CITY OF PORTLAND PERMITS DIVISION

Permit Number: 031289

Location of Construction: 789 Warren Ave	Owner Name: Kevin Bosworth	Owner Address: 789 Warren Avenue	Phone: 828-0110
Business Name:	Contractor Name: Dahlgren Construction, Inc.	Contractor Address: 412 US Route 1 Yarmouth	Phone:
Lessee/Buyer's Name	Phone:	Permit Type: Additions - Commercial	Zone: IM

Past Use: Arbor Care Landscape/Commercial	Proposed Use: Arbor Care Landscape/Commercial	Permit Fee: \$285.00	Cost of Work: \$20,500.00	CEO District: 1
Proposed Project Description: 22' x 30" Addition to Existing 40' x 70' Metal Garage 22'6" x 30'		FIRE DEPT: <input checked="" type="checkbox"/> Approved <input type="checkbox"/> Denied	INSPECTION: Use Group: 51 Type: 2B 11/26/03 Signature: <i>[Signature]</i>

FOUNDATION PLAN AND DETAILS  
ARBOR CARE  
PORTLAND, MAINE

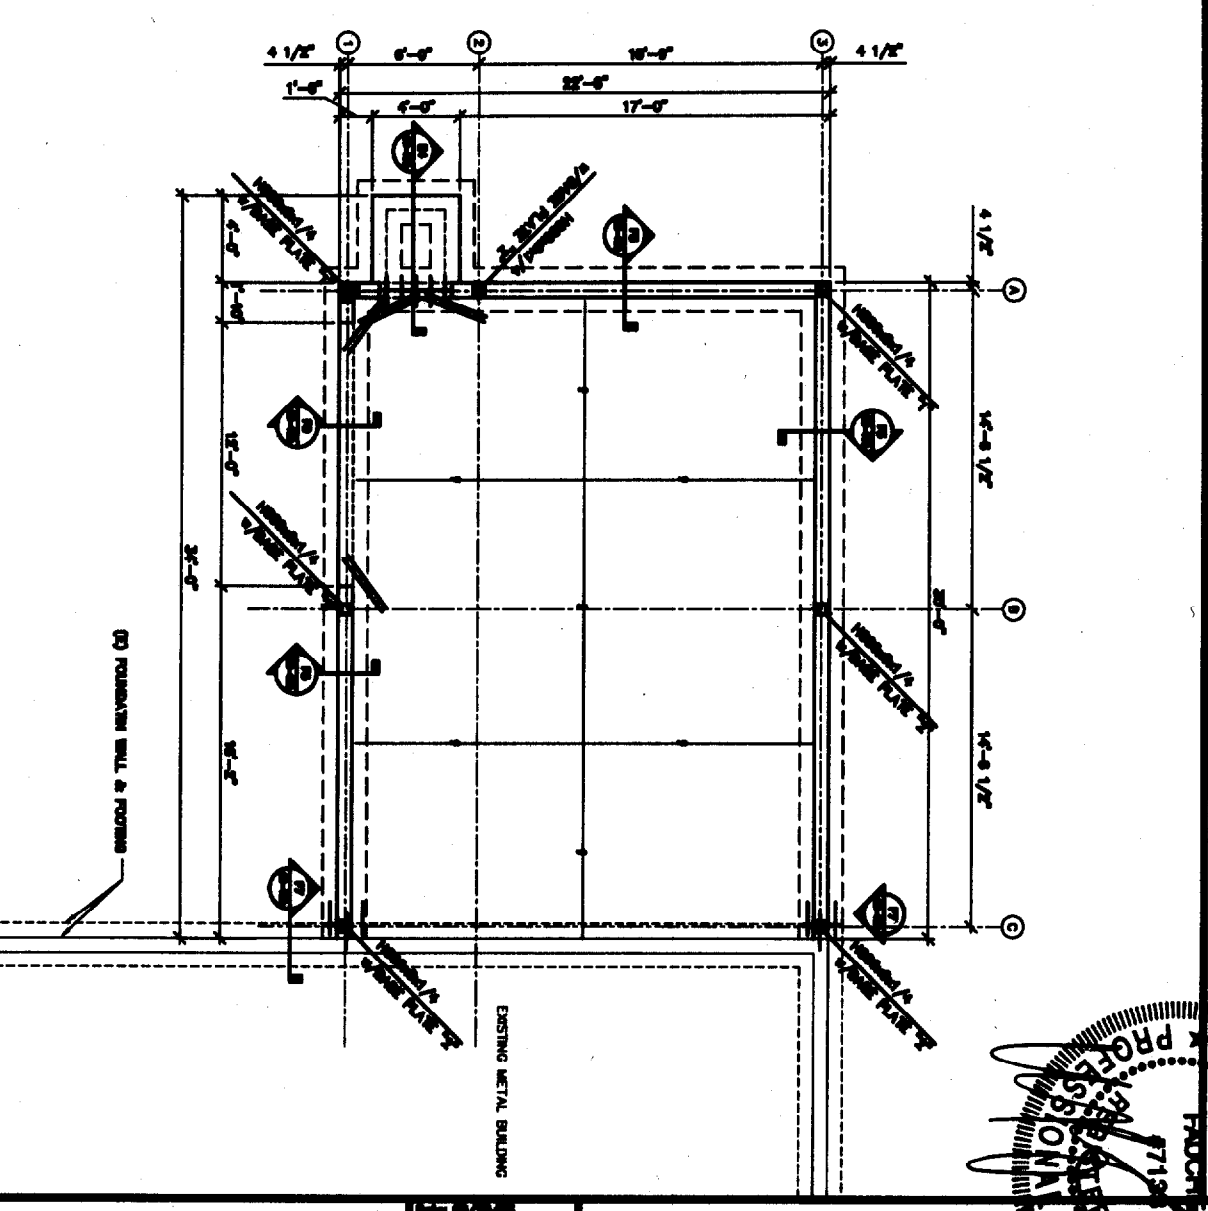
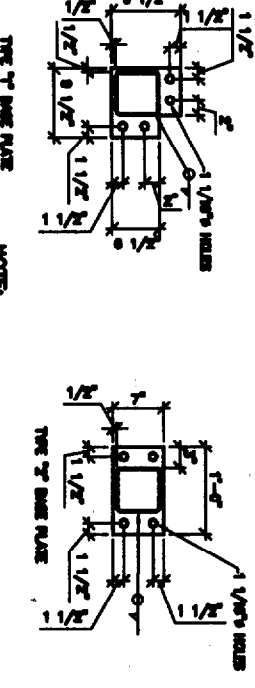
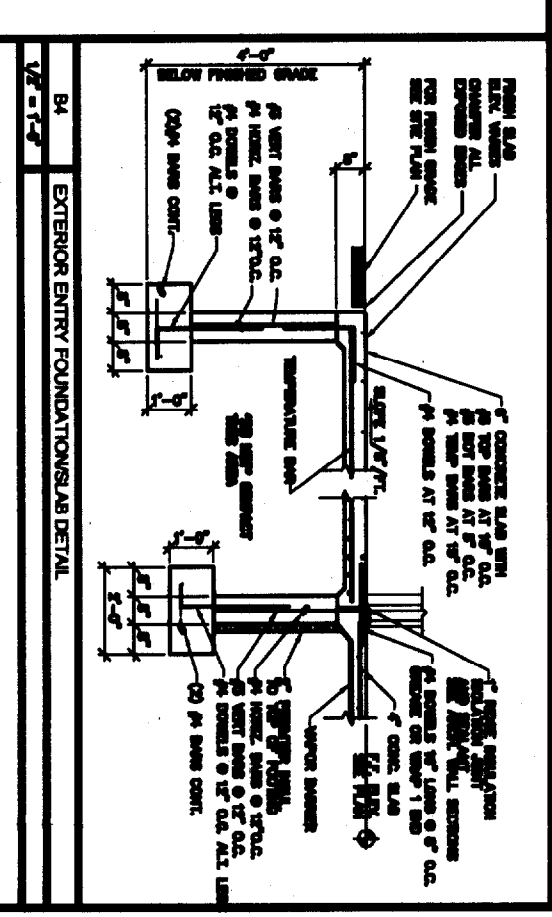
11/14/2003-mjn: Left a message with the designer to indicate use group and type of construction, also special inspections of steel fasteners
